**Re: Objection against SSD-77211717 – Lot 303 Croatia Avenue, Edmondson Park**

Bathla Group is the registered proprietor and consent holder for the mixed-use apartment precinct currently the subject of an active and approved Development Application for 164–170 Croatia Avenue, Edmondson Park (Lots 25 & 26 DP 228850).

Drawing Name
Sections

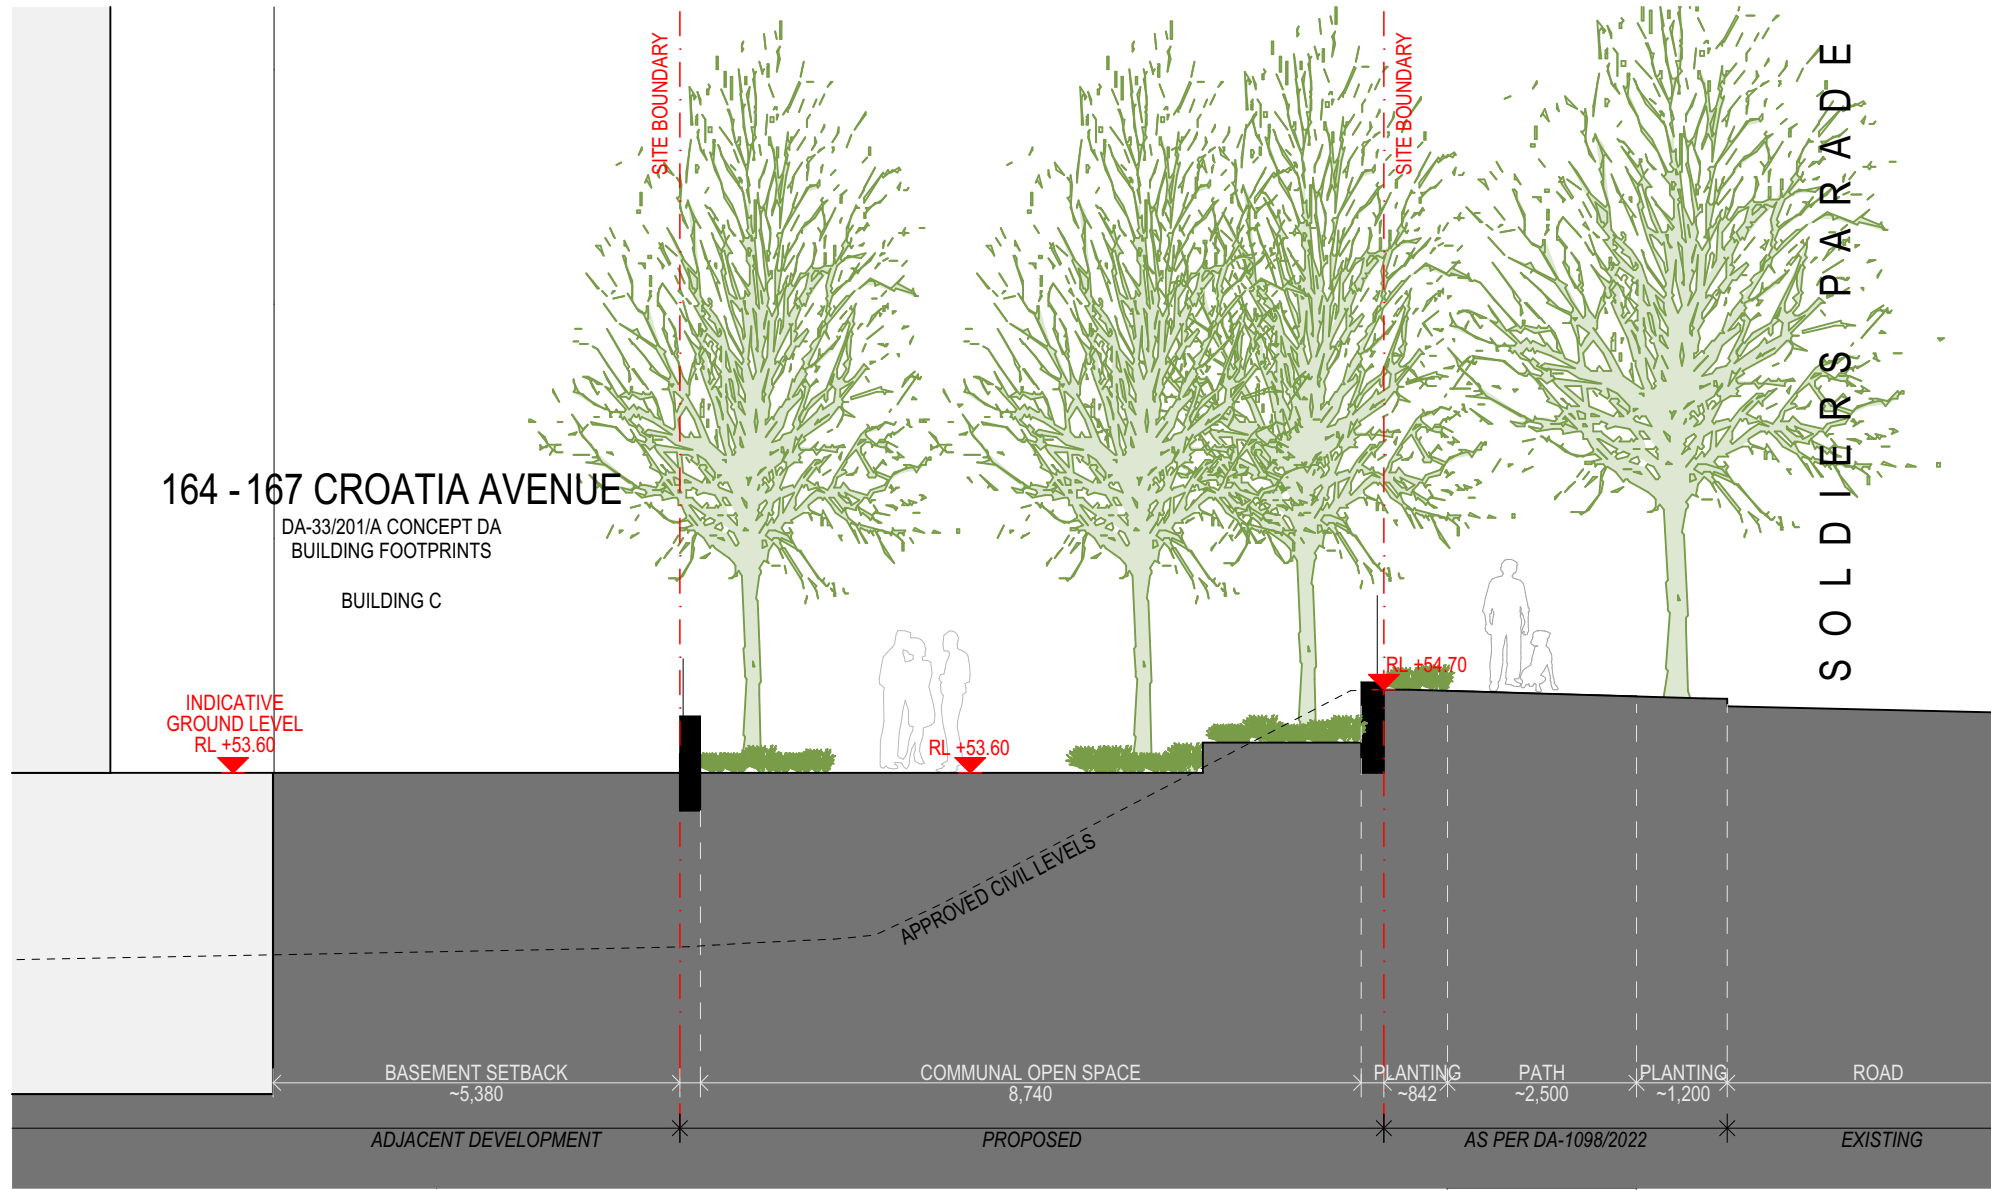
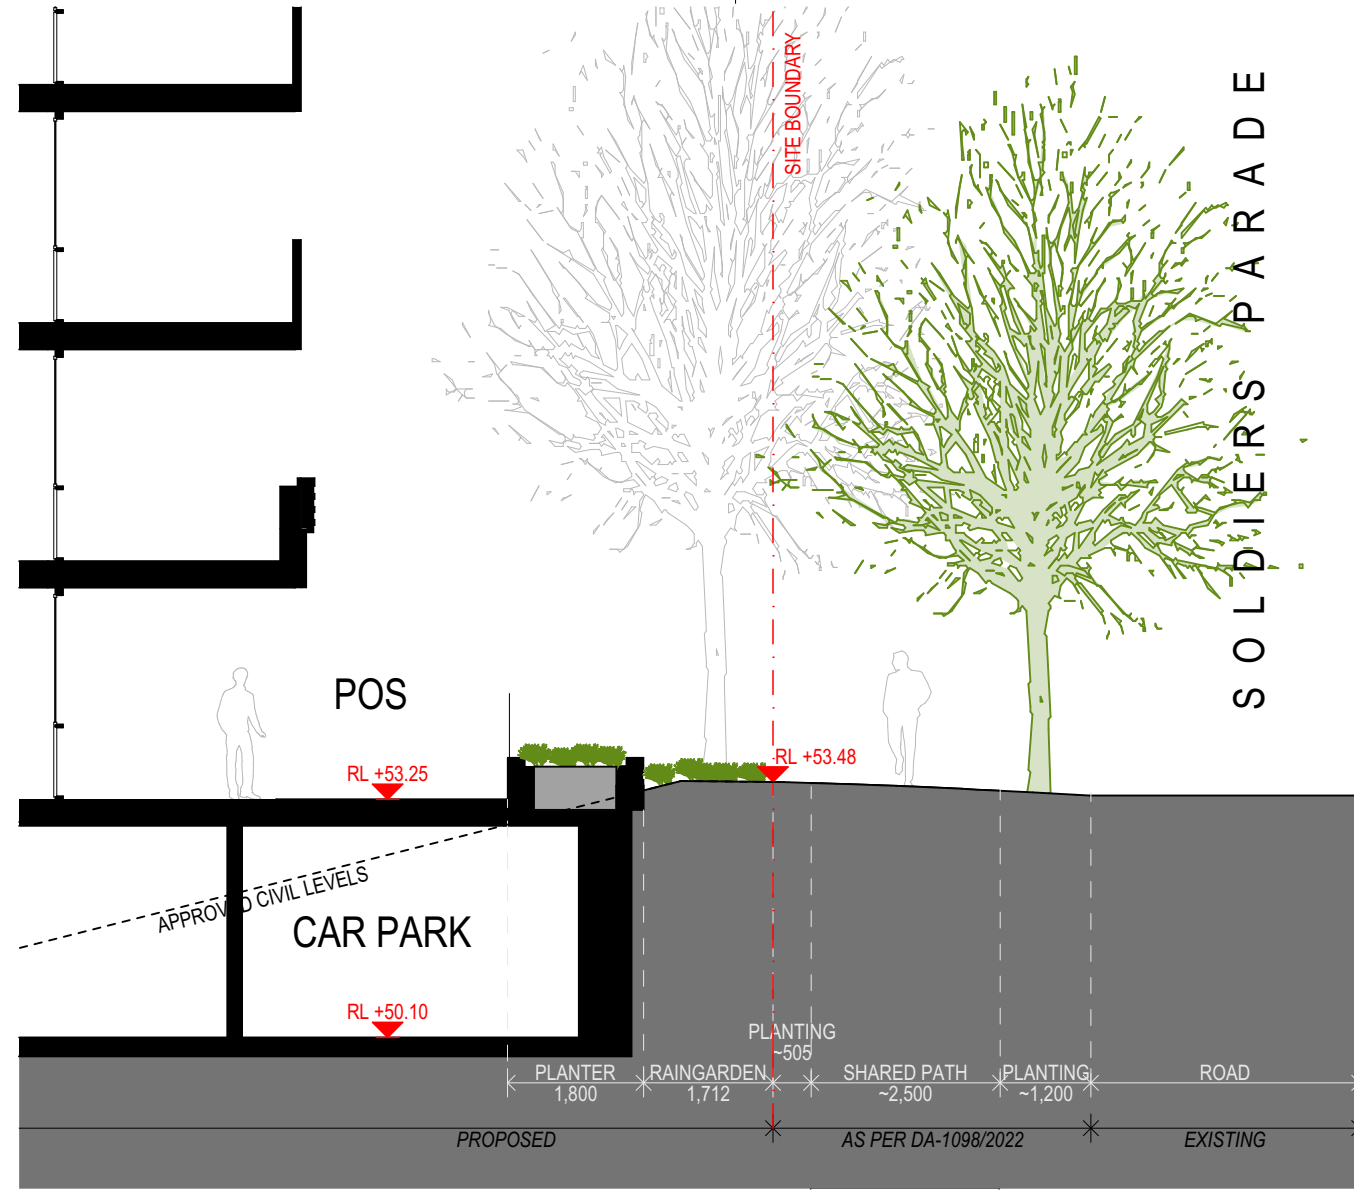
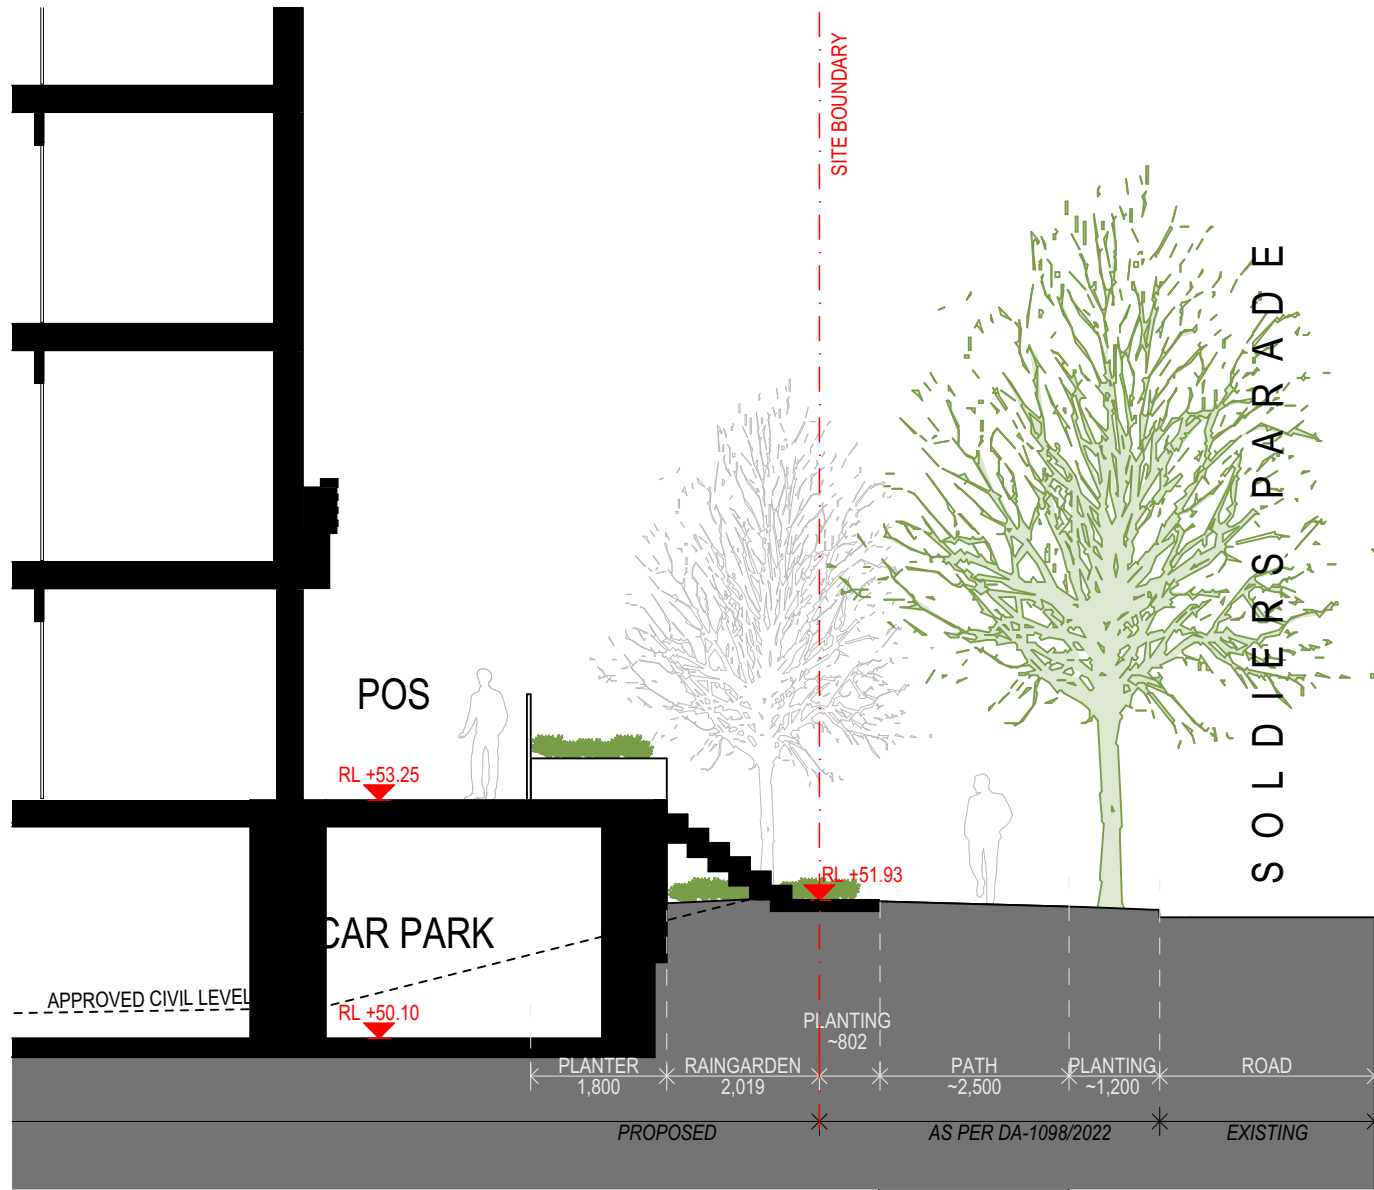
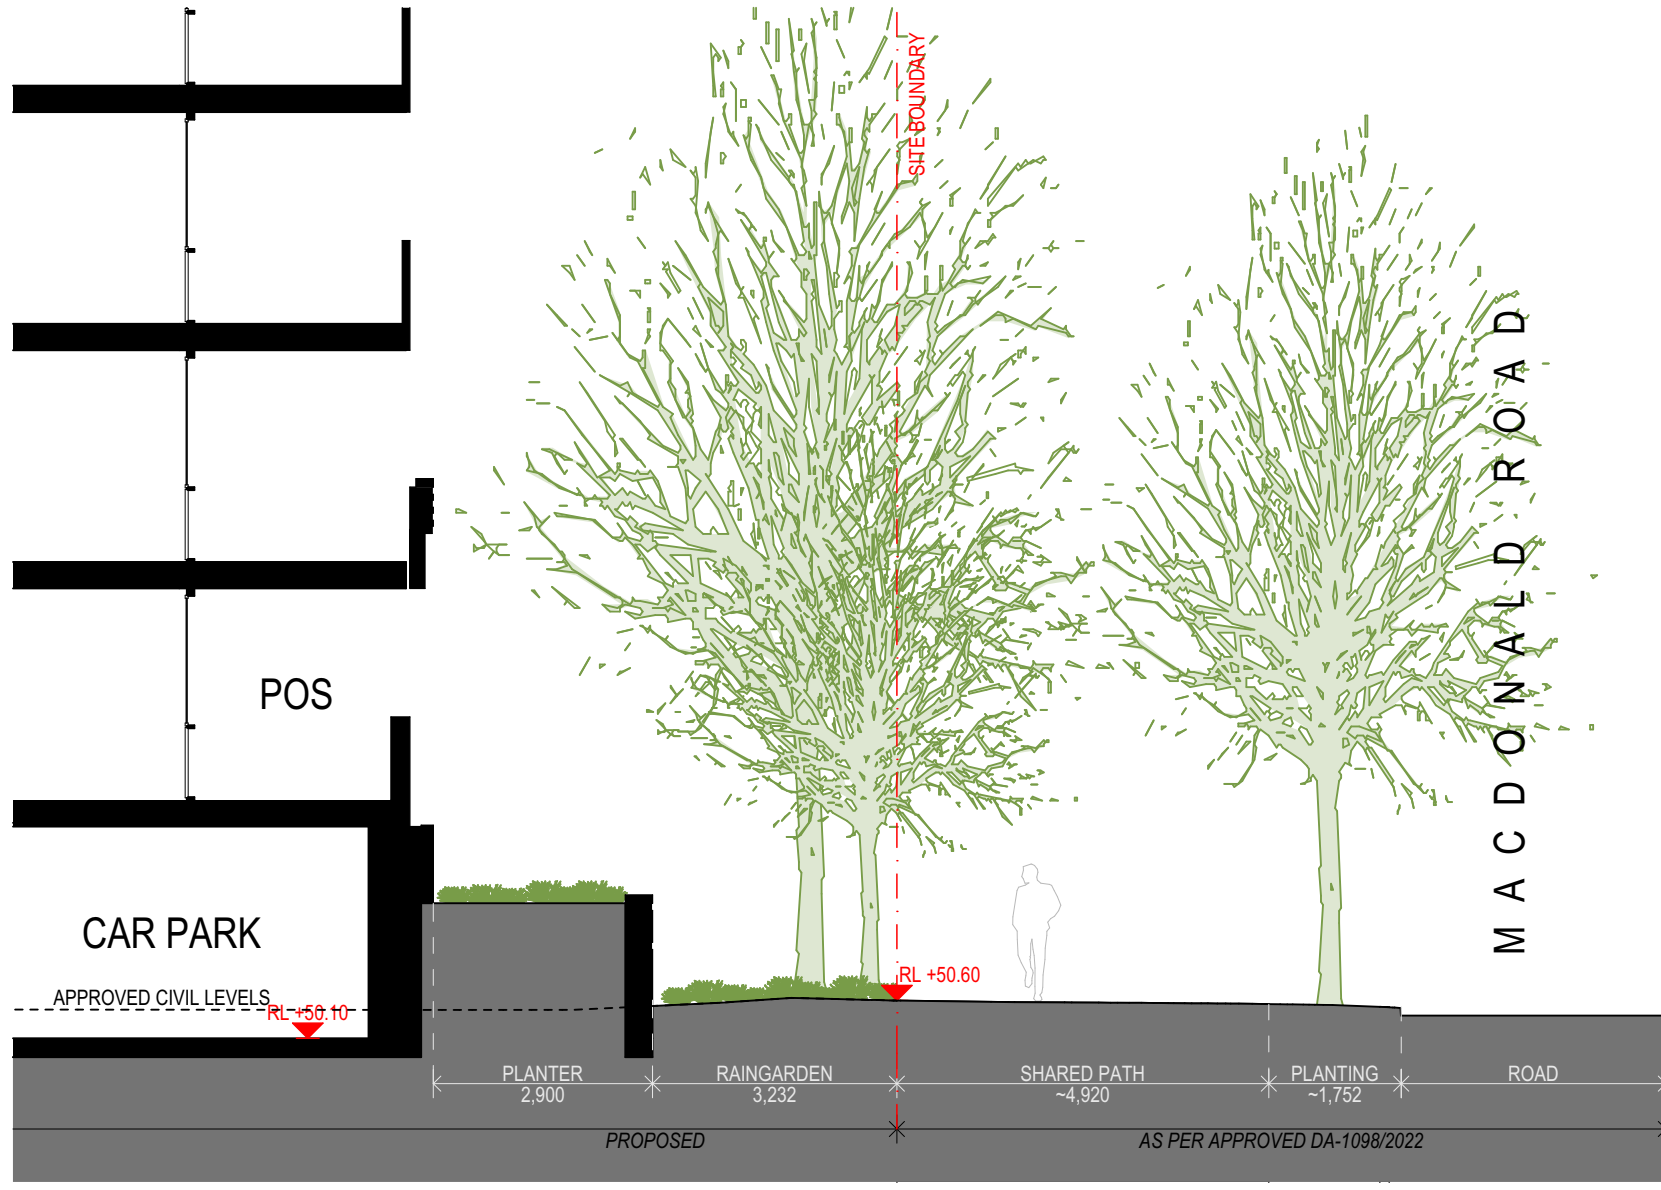
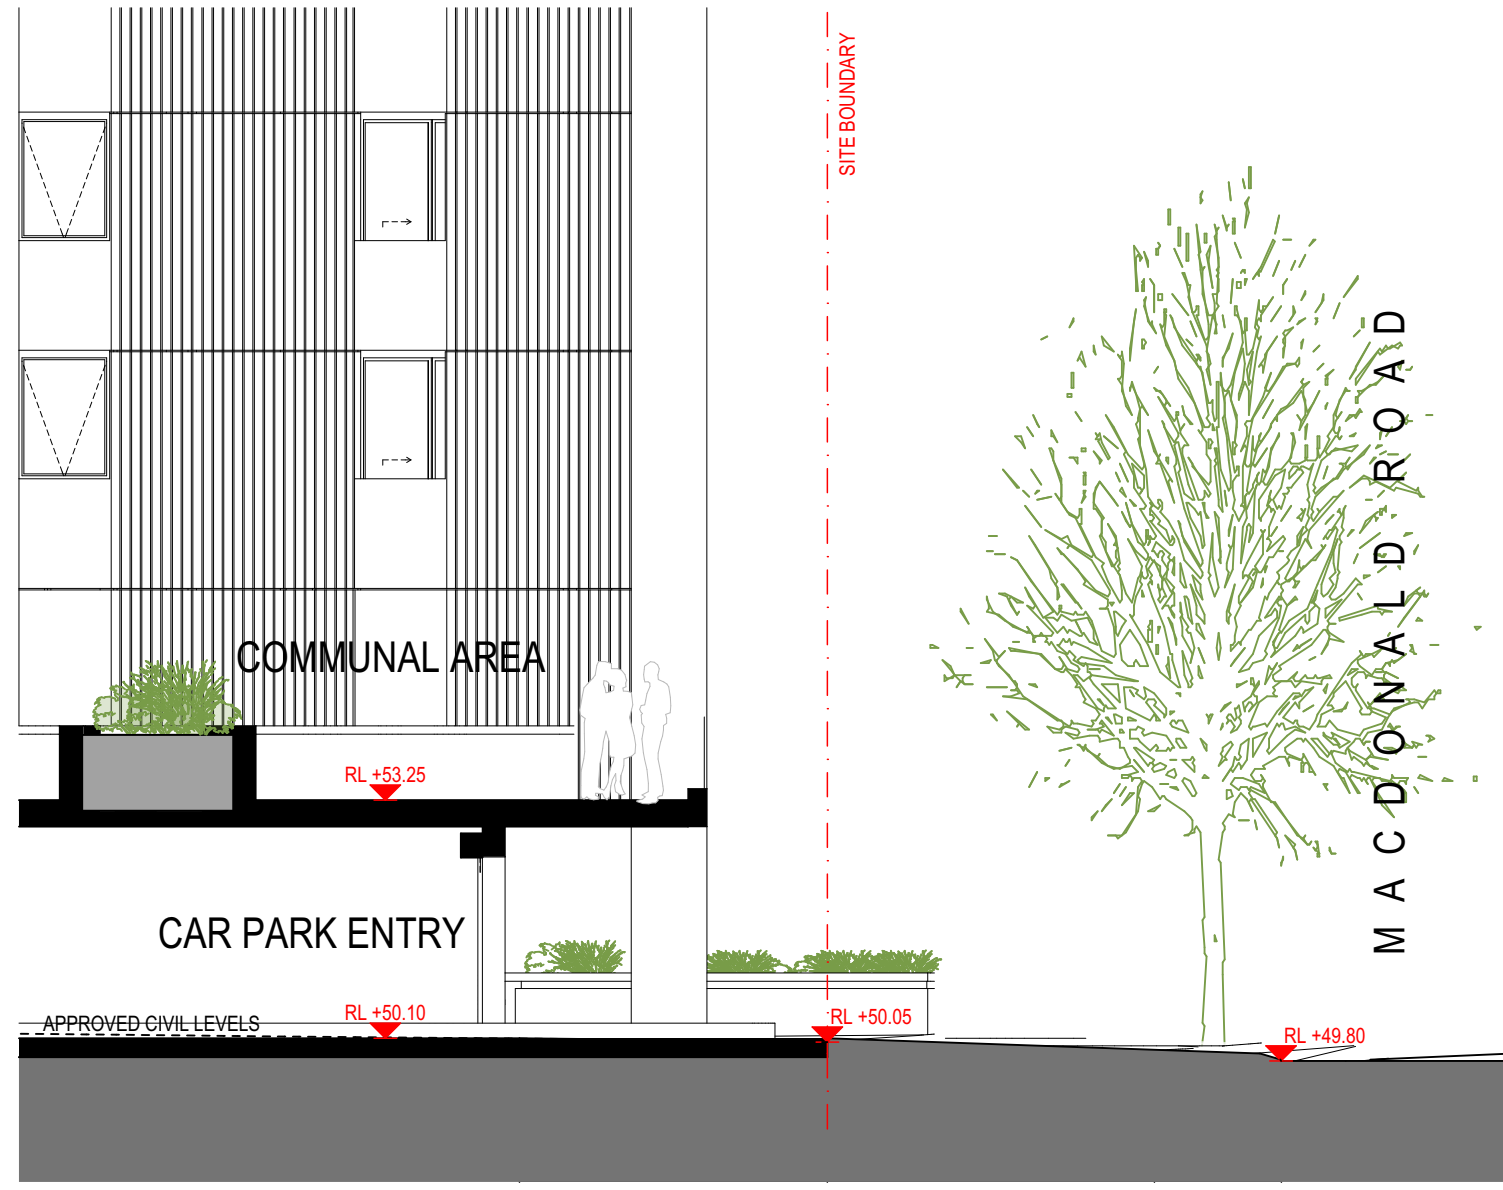
- (1) Communal Open Space: Afternoon overshadowing of our landscaped courtyards contravenes ADG 3D-1, diminishing winter usability.
- (2) Visual Privacy: Direct inter-apartment sightlines at distances < 12 m breach ADG 3F-1, eroding resident privacy.
- (3) Streetscape: The continuous podium and minimal articulation along Soldiers Parade fails LDGP 10.5 objectives for a “human-scaled, fine-grained street edge”.

- (1) Refuse the SSD in its current form or Require substantial design amendments, specifically:
  - (i) Reduce Block 24 height by at least two storeys;
  - (ii) Introduce a minimum 6m setback from any part of the building and 9m upper-level setback from the common boundary;
  - (iii) Articulate façades and break building mass into smaller elements;
  - (iv) Provide verified shadow diagrams demonstrating that ≥ 70 % of dwellings on adjoining sites still receive the minimum 2 hours solar access at mid-winter, with ≤ 15 % receiving none.
